# CITY OF PORTLAND BUILDING PERMIT

Located At 15 ALLISON AVE

Job ID: 2012-11-5356-SF

**From:** Jonathan Rioux <JRIOUX@portlandmaine.gov>  
**To:** dkchrist59@yahoo.com  
**Sent:** Friday, November 30, 2012 1:19 PM  
**Subject:** 15 Allison Ave.

1ST FLOOR PLAN
SCALE: 1/4" = 1'-0"

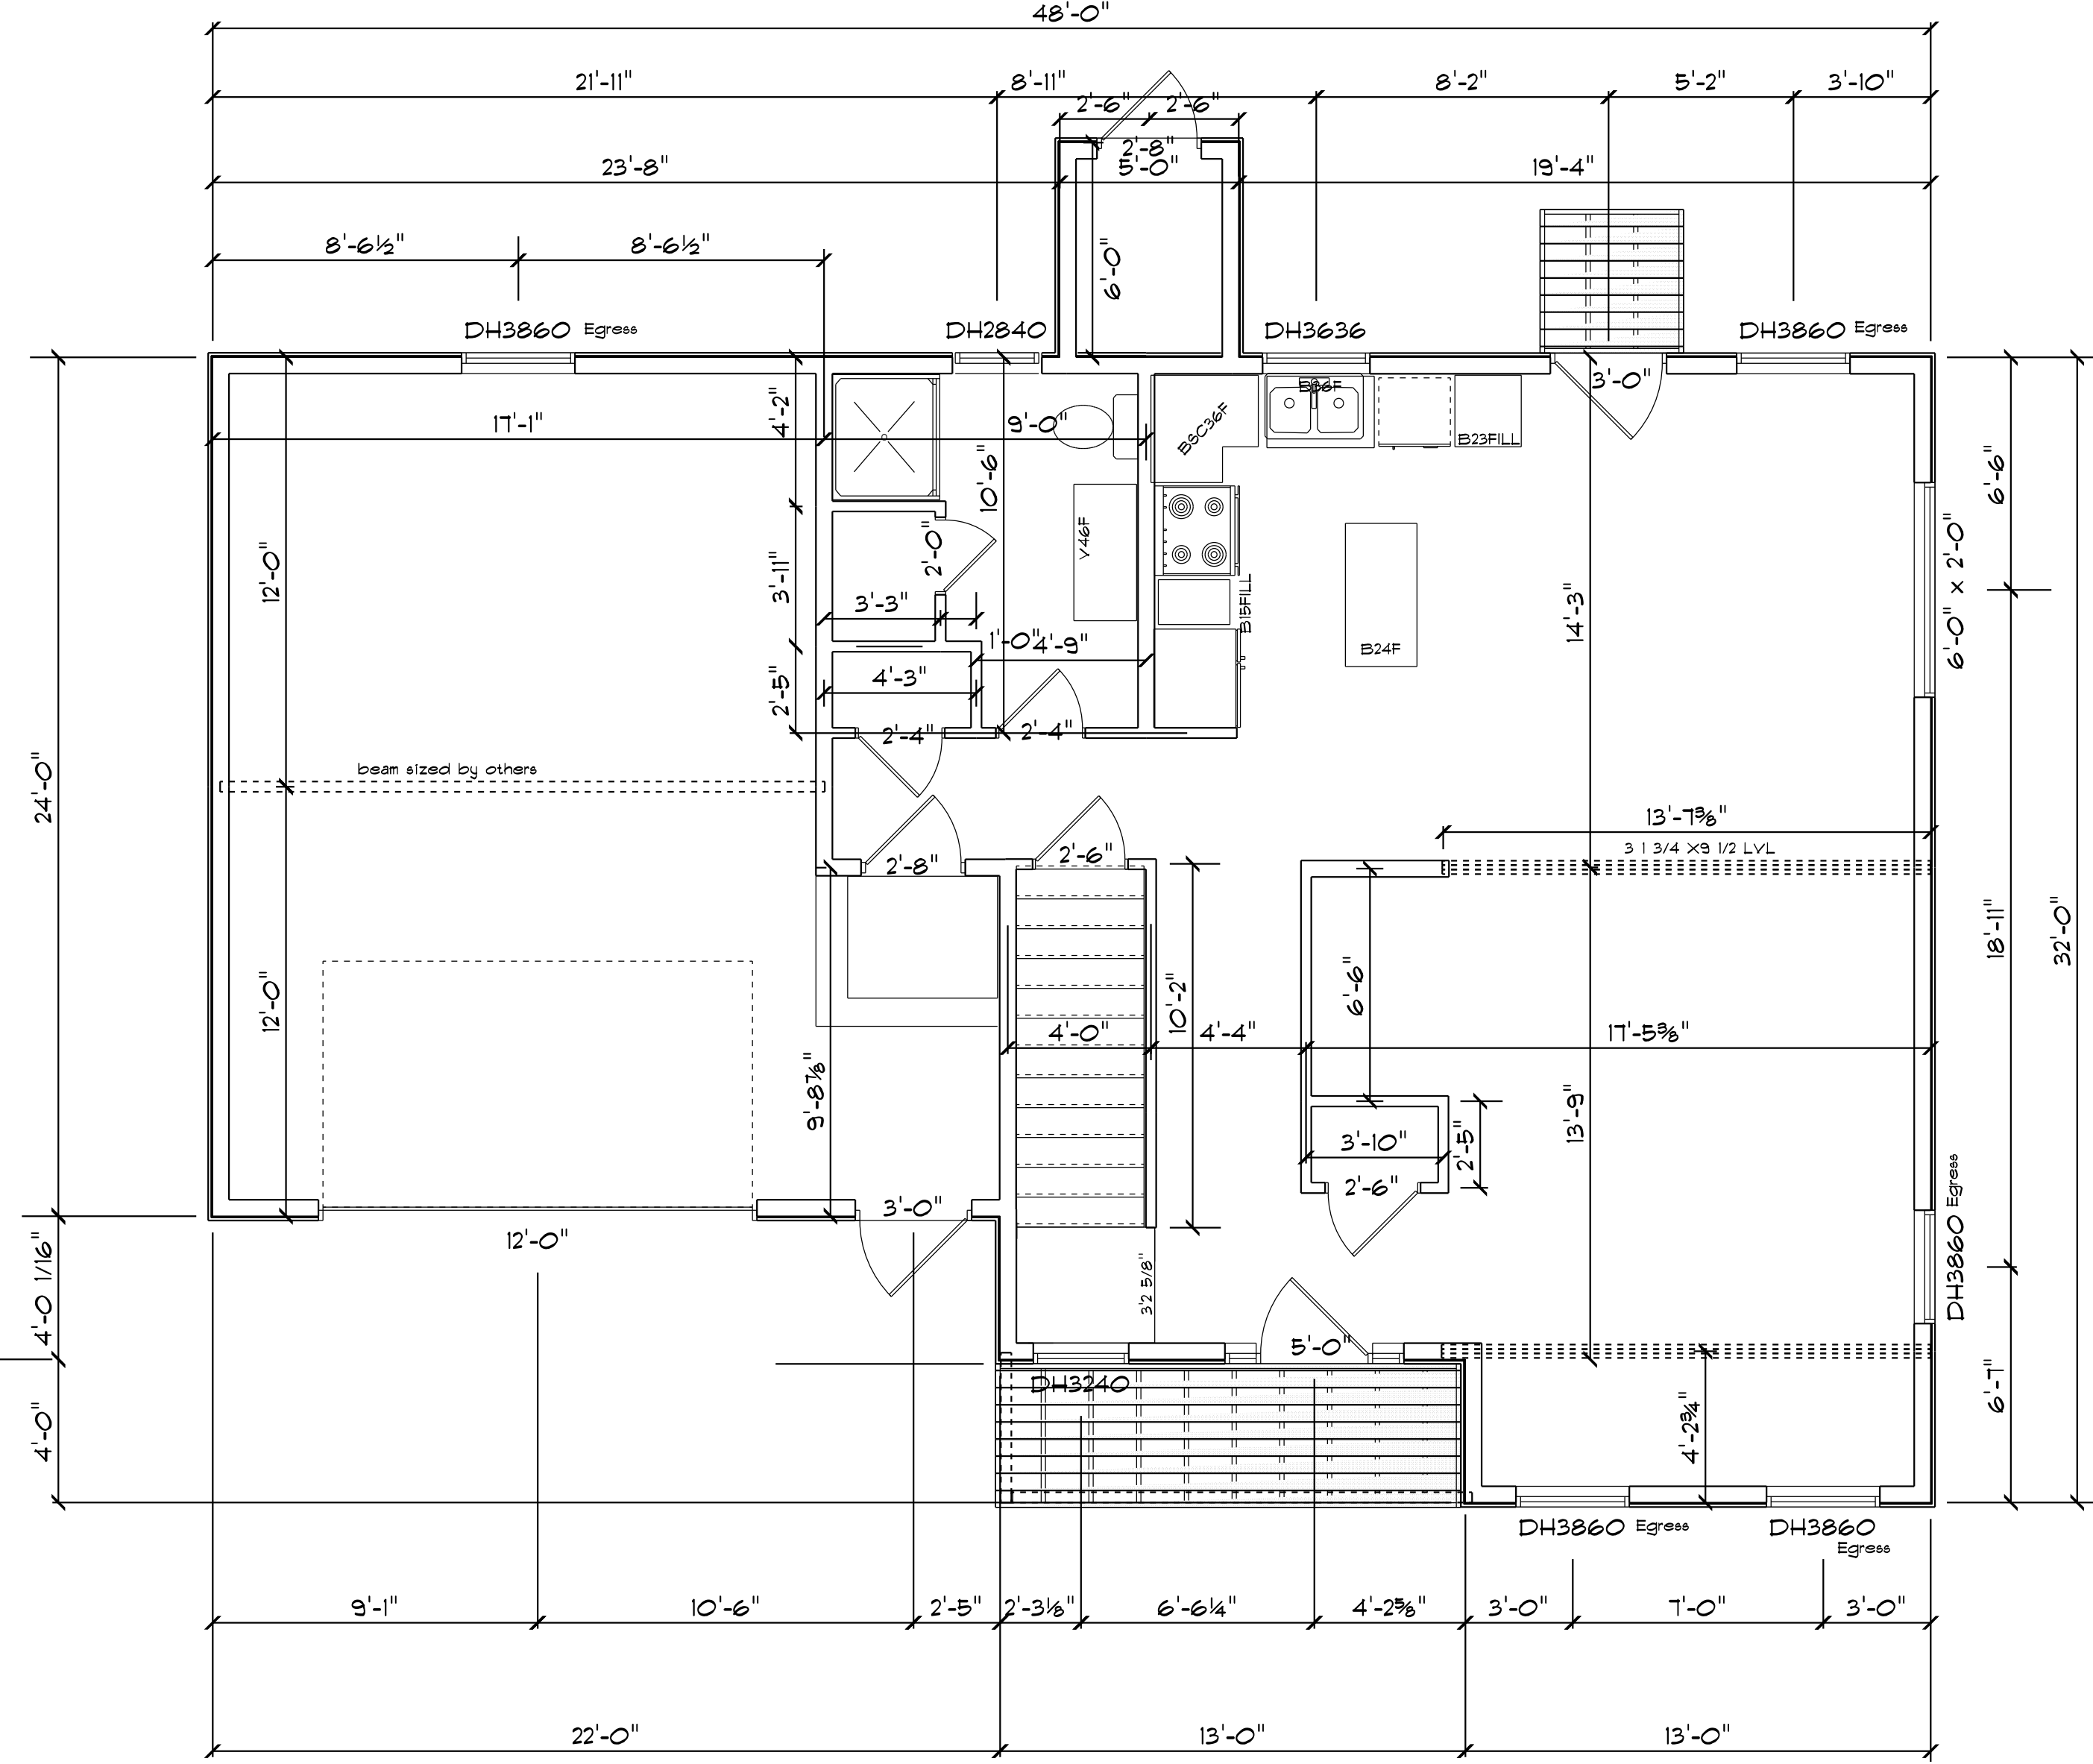
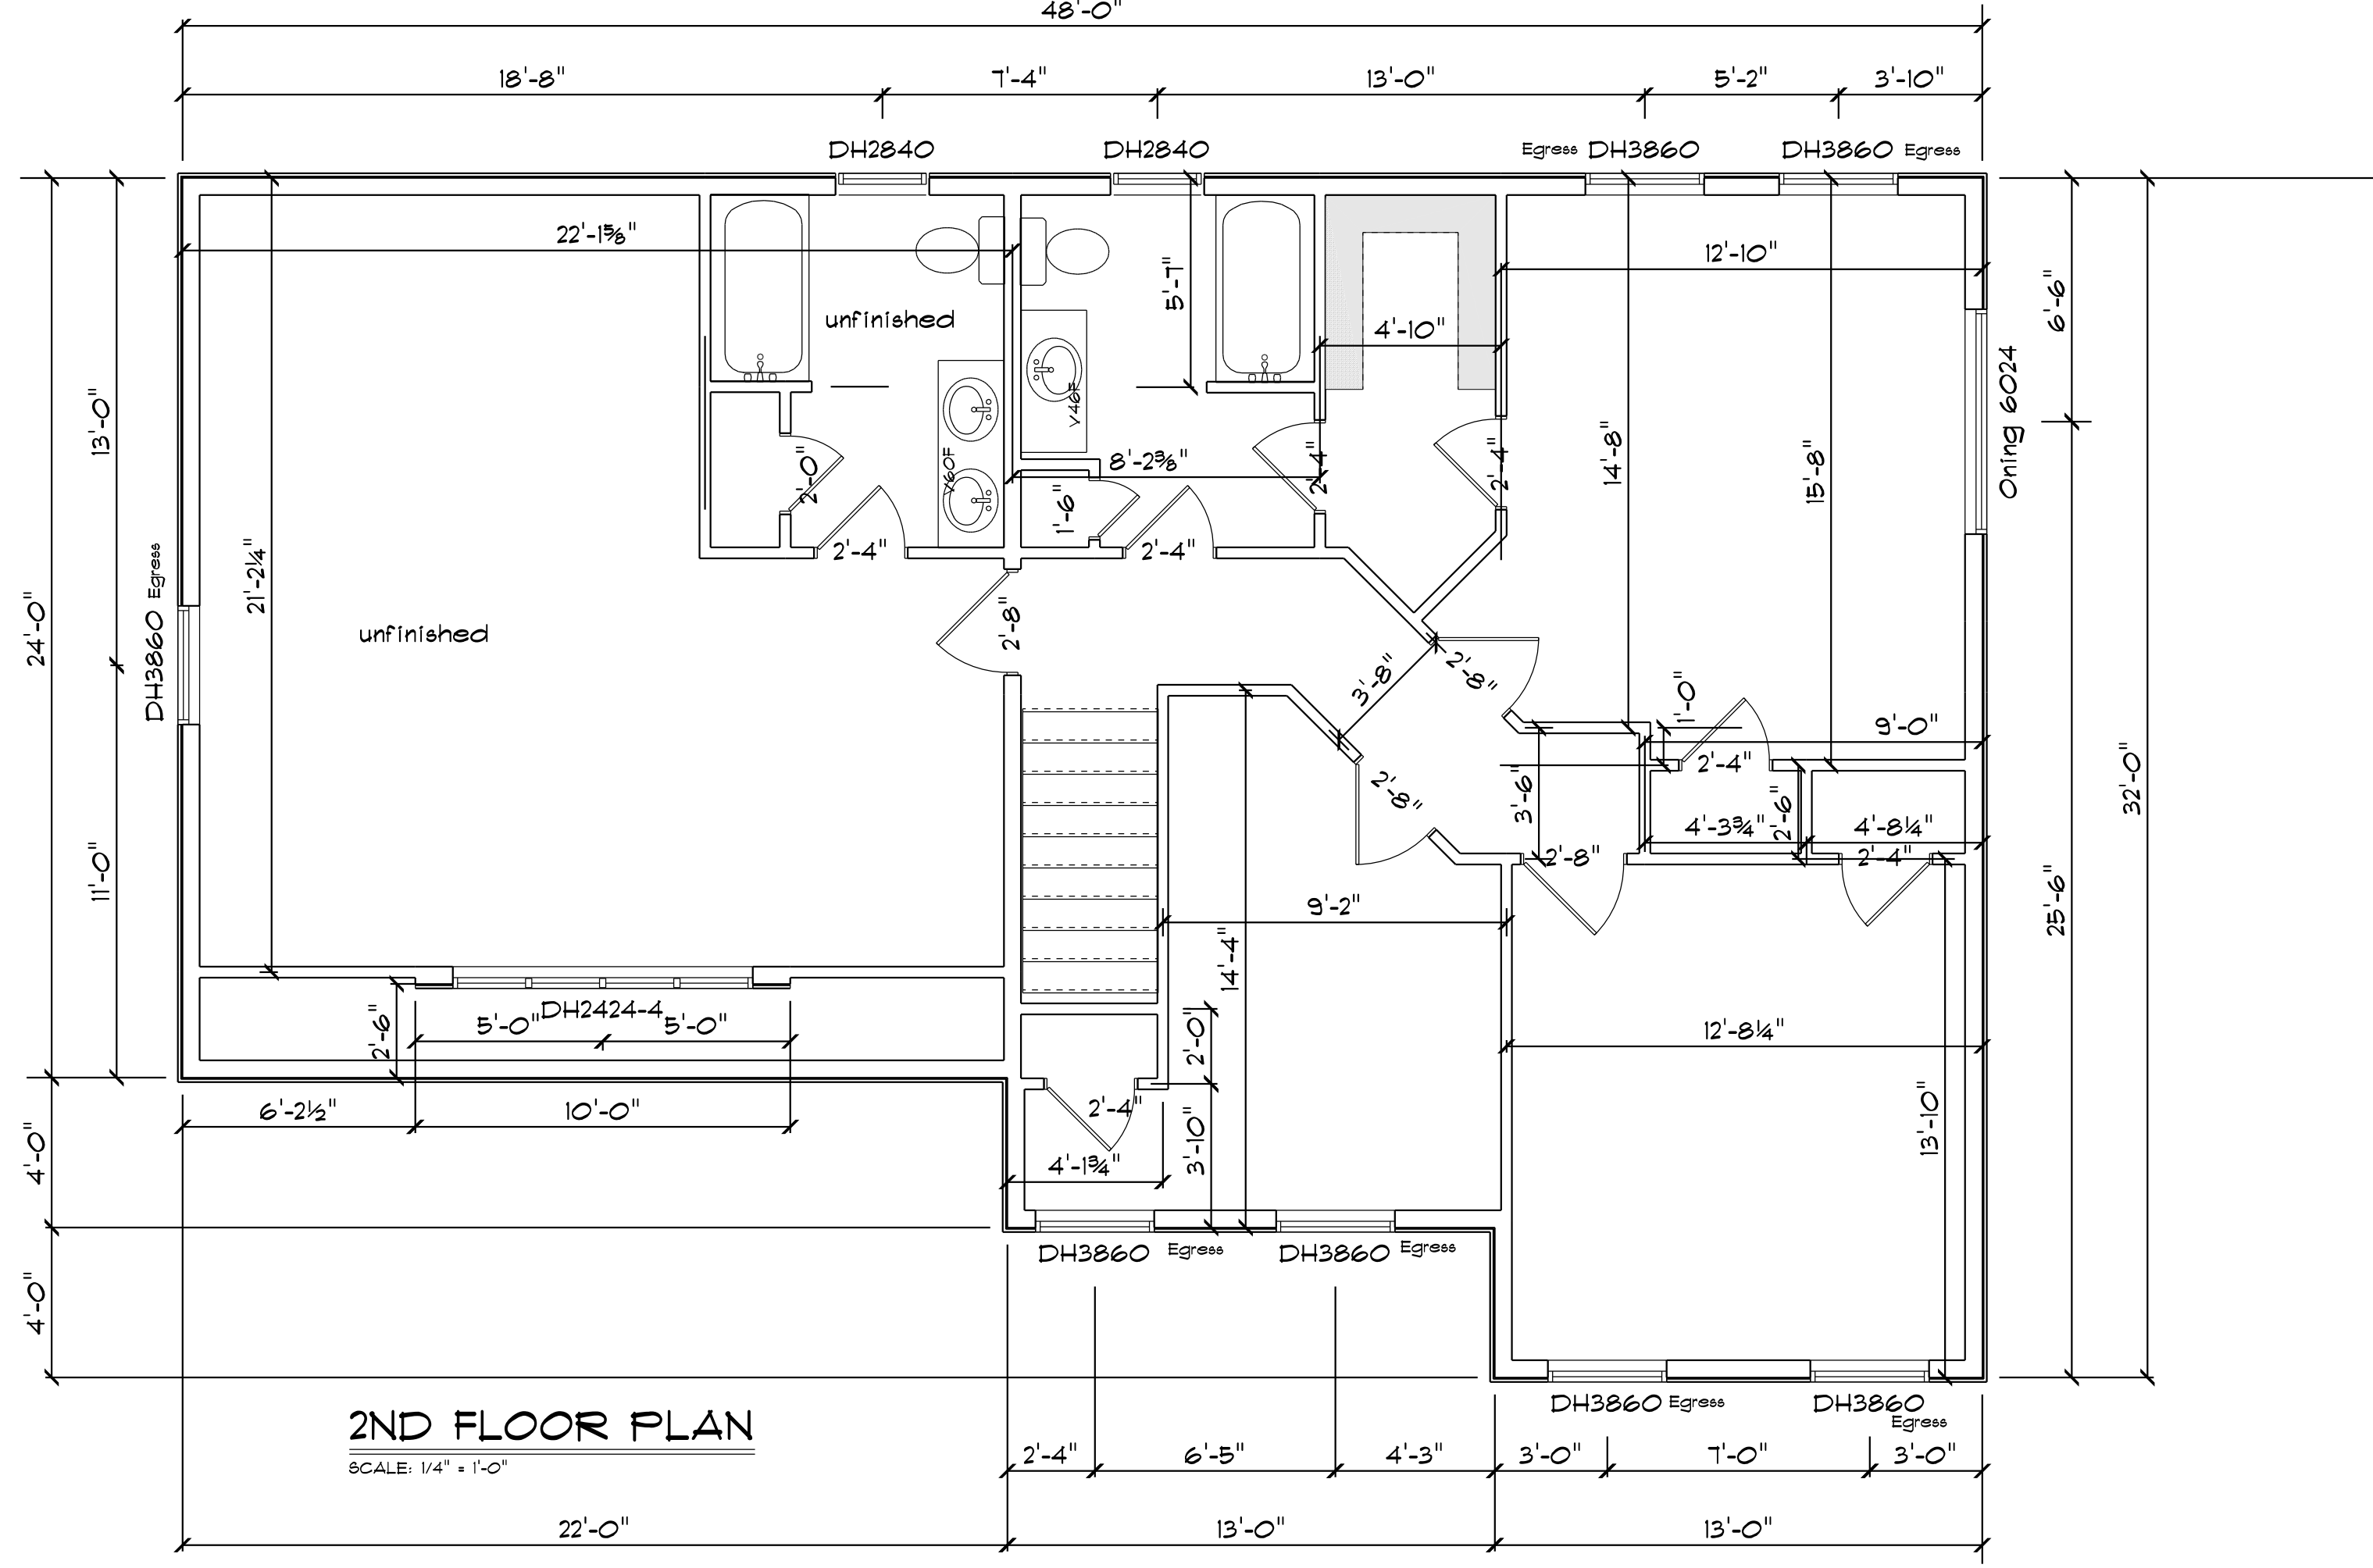
The information below was missing on the building permit application. The floor framing plans/ cross sections need to indicate the (3) 2 x 12 girder spans/ spacing between each lally column; the roof framing plan must show how the dormer meets the 2 by 10 inch rafters, with finished headroom. All bulleted items require a response for permit issuance.

- **Dimensions and Spacing** dimensions are on floor plan. spacing is shown in the cross section
- (Table R502.3.1(1) & Table R502.3.1(2) )

Thanks for your feed back. I am wondering if you have a complete set of plans where as most of what you have listed is on the plans. The spacing for the columns is in the foundation plans. The size of the girder is in the cross section. I have attached the plans in case you are missing a page. I started to go through your list and am realizing that I should just schedule a time to meet with you to go through this since I to have questions as to what you are asking for. I will bring in anything that is not listed on the plans with me as you have noted. I will call later to try and set up a time to meet sometime this week.
